Recommendation Report for Lawful Development Certificate for a Proposed Use or Development

REF NO: AB/114/18/CLP

LOCATION: 31 Tarrant Street (1st & 2nd Floor Flat)
Arundel

PROPOSAL: Application for a Lawful Development Certificate for a Proposed use - replacement windows

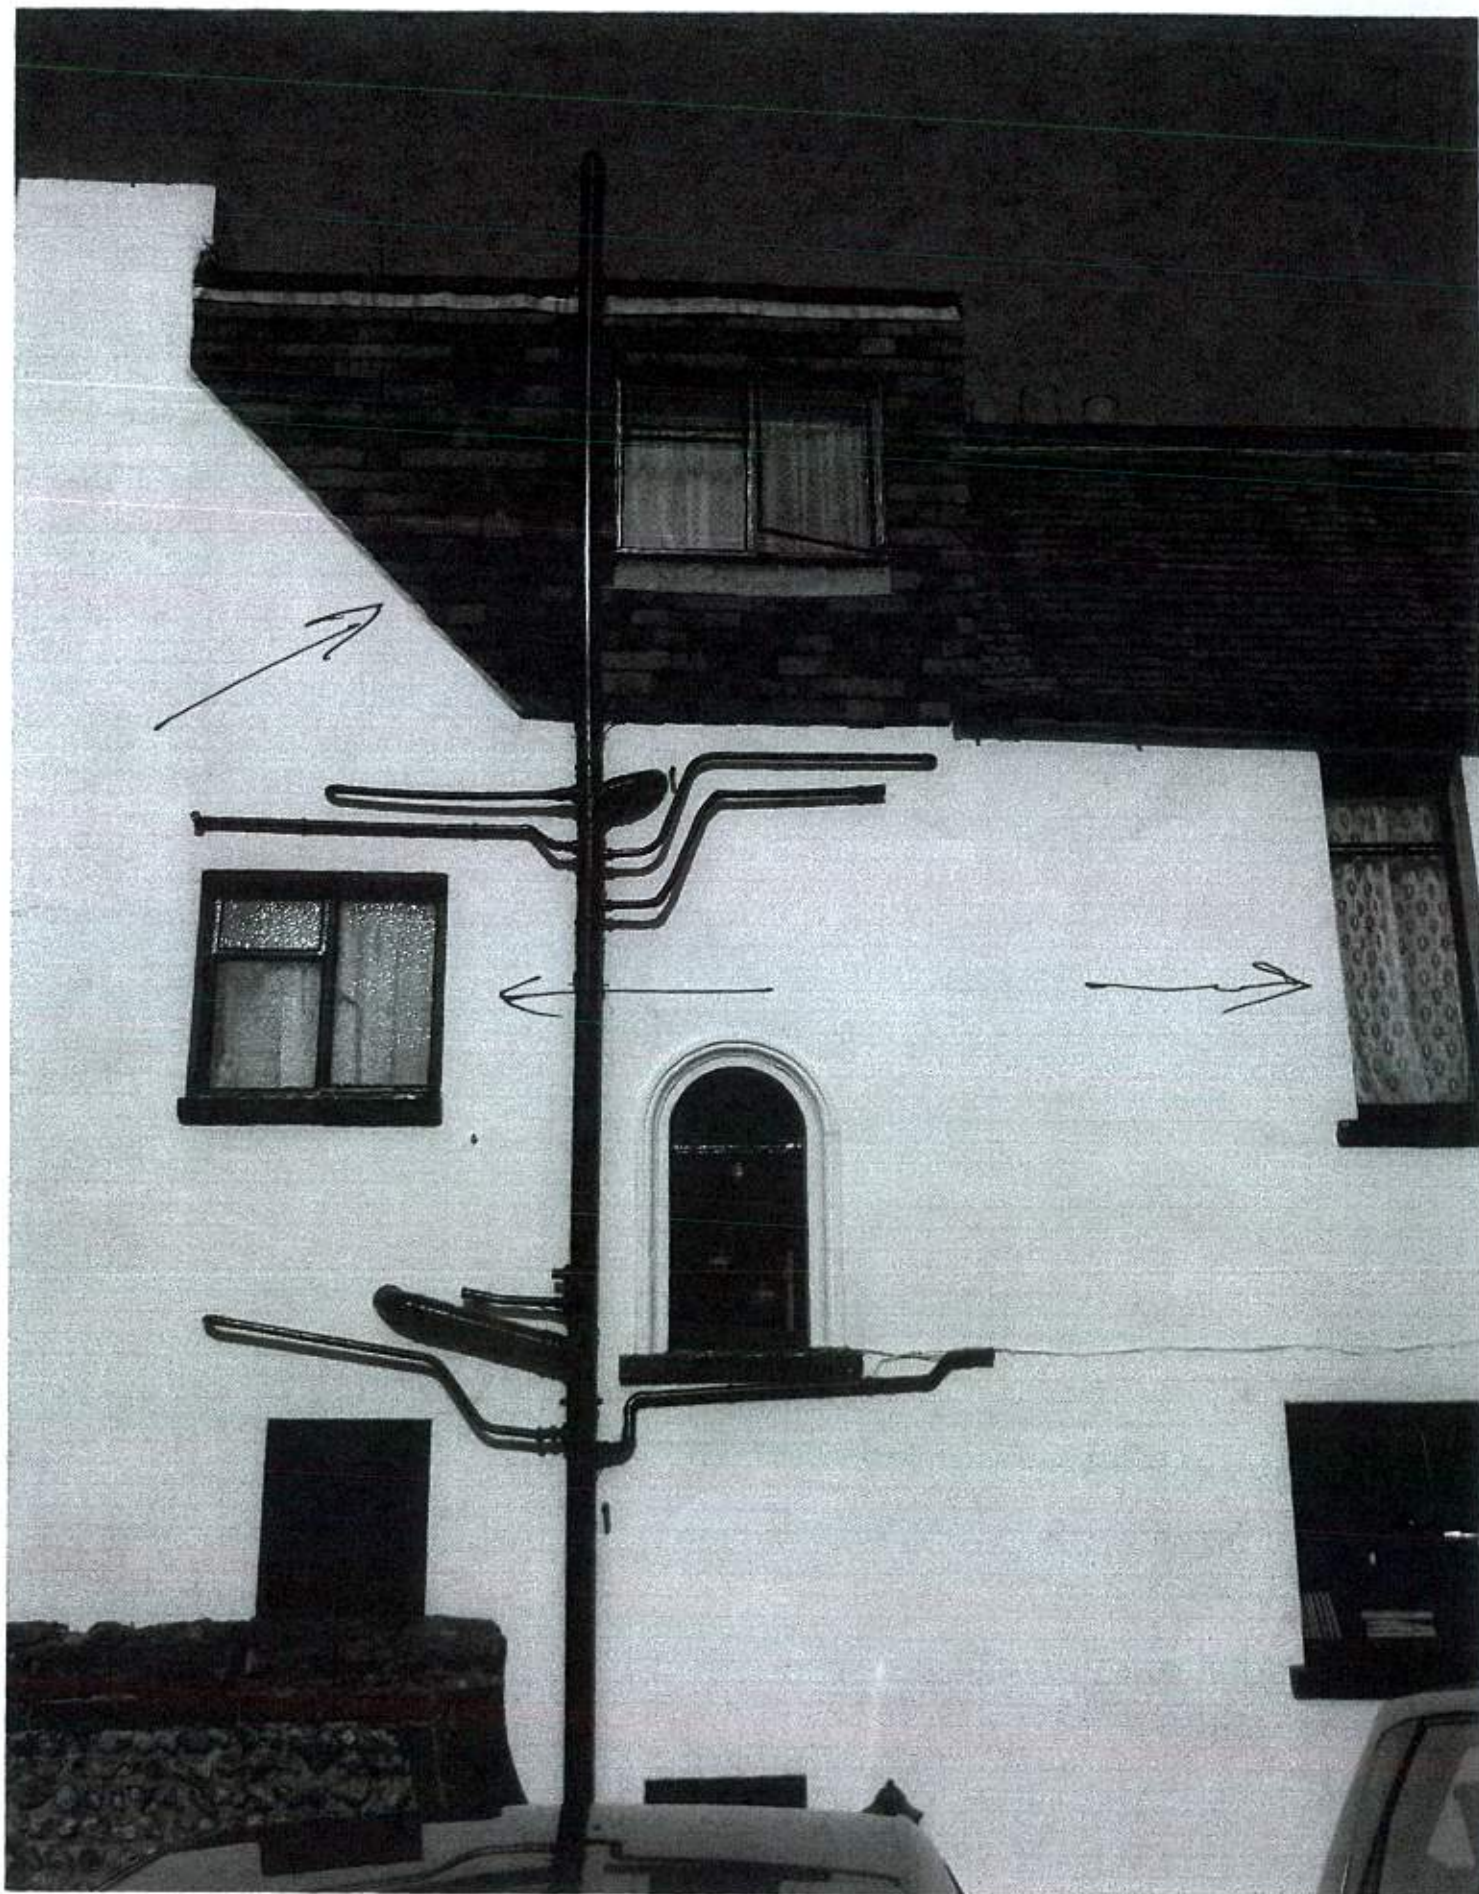
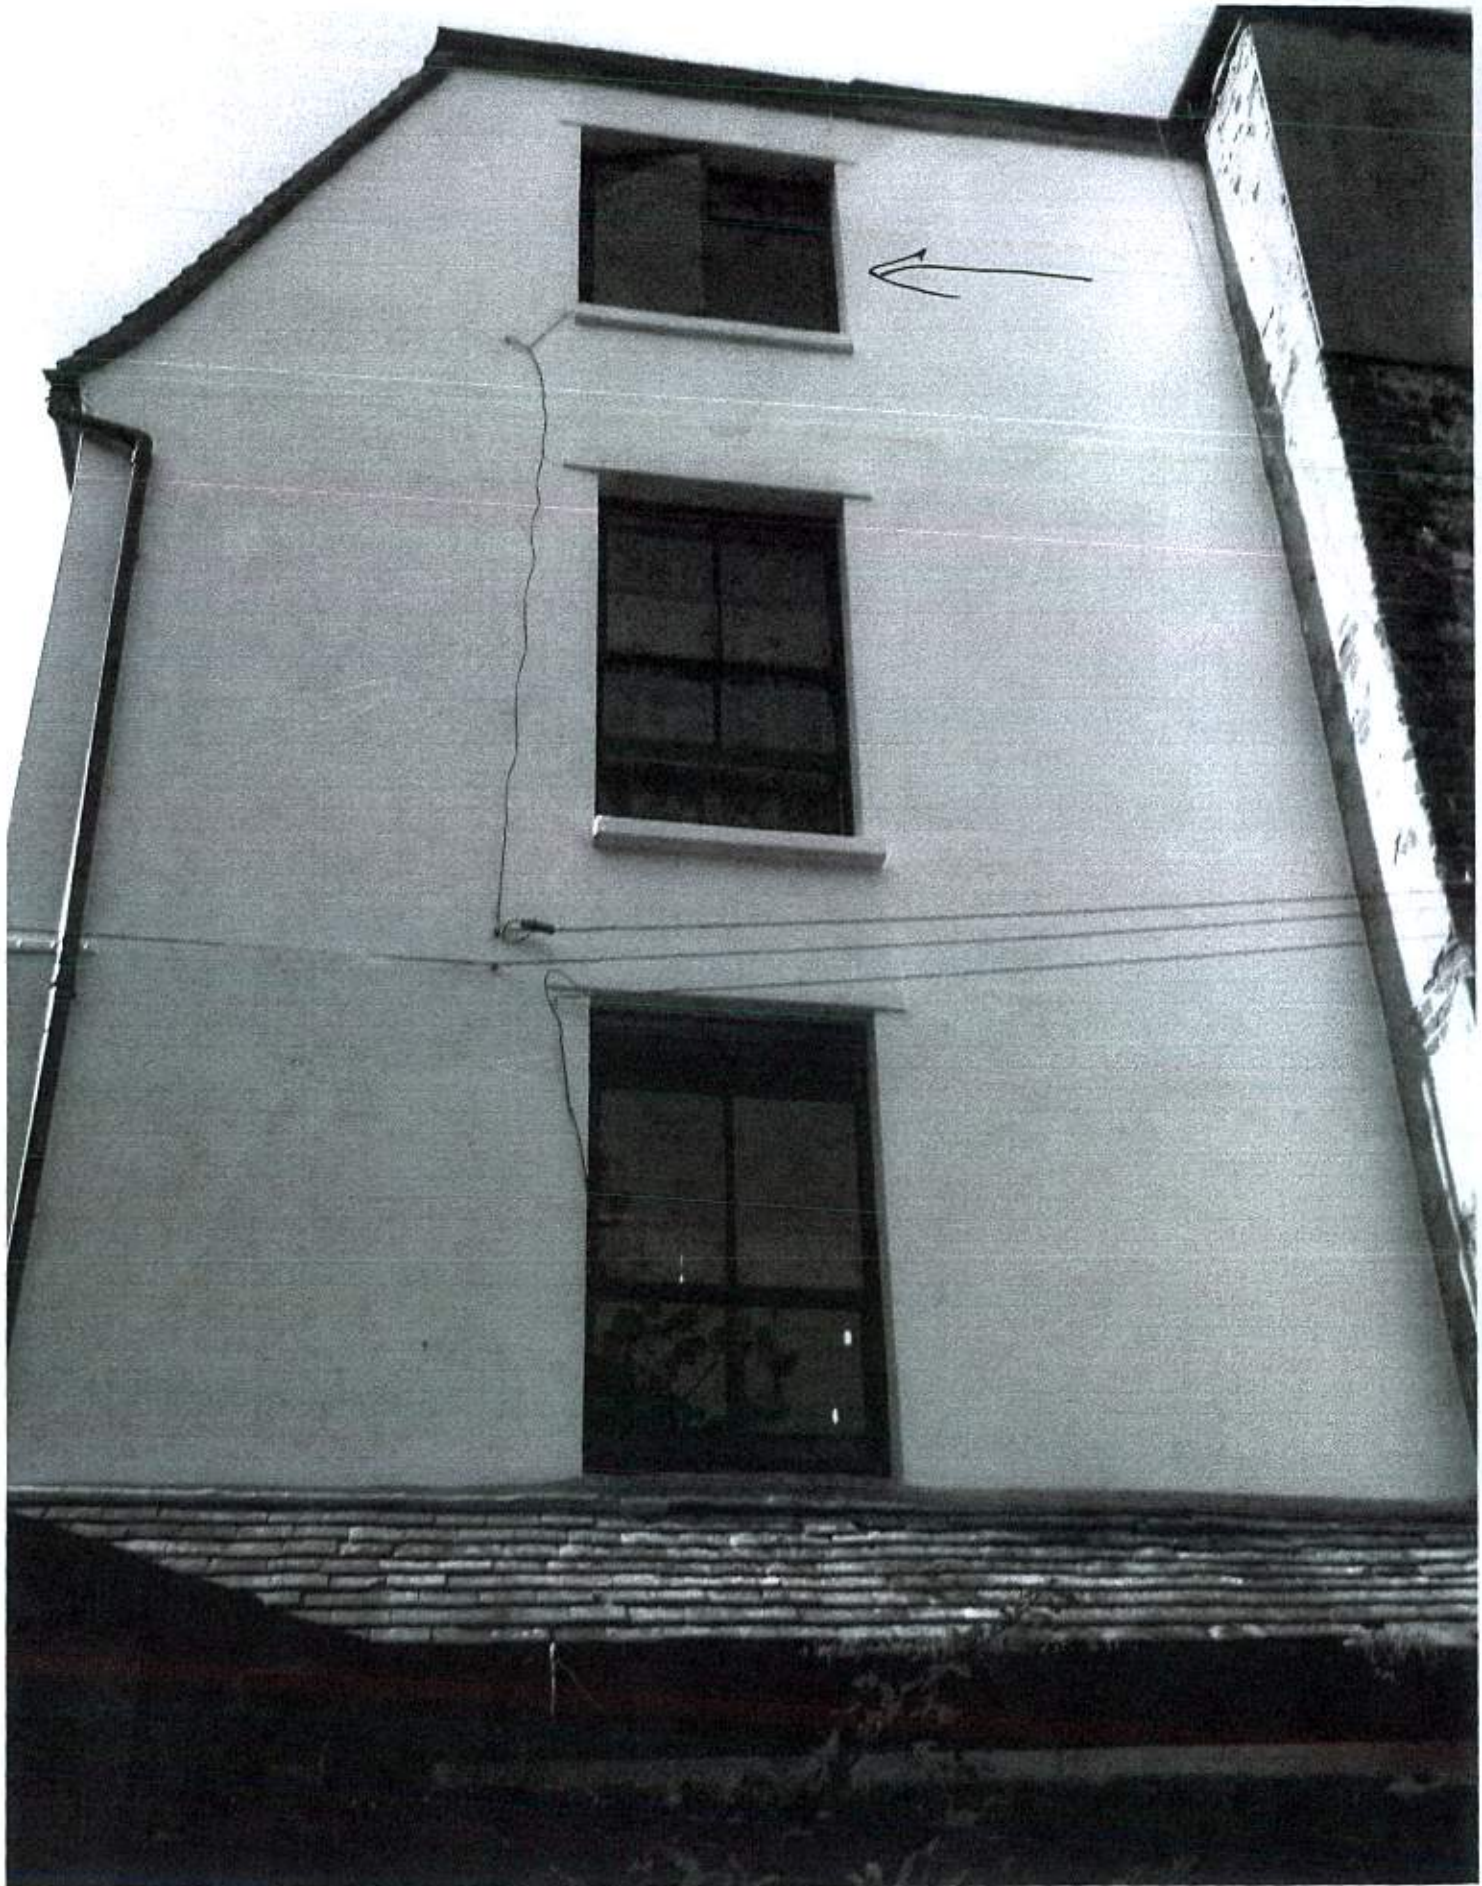
The Conservation Officer has indicated that the proposed replacement windows in this application would be materially different in appearance to those currently in situ. This is resultant of their design (with regard to thickness and orientation of glazing bars), detailing (the materials and construction of the windows) and operation (layout of openings and how they work). Additionally, the modern shiny plastic, and sheen of double glazing is out of keeping with the existing, traditional materials.

- The replacement windows are considered, by virtue of their design, detailing and operation make them appear different to traditional windows, and the visual effect for plastic is out of keeping with more traditional materials. Therefore, the proposal is considered to have a material impact on the external appearance of the dwelling, in conflict with Section 55 (2)(a)(ii) of the Town & Country Planning Act.
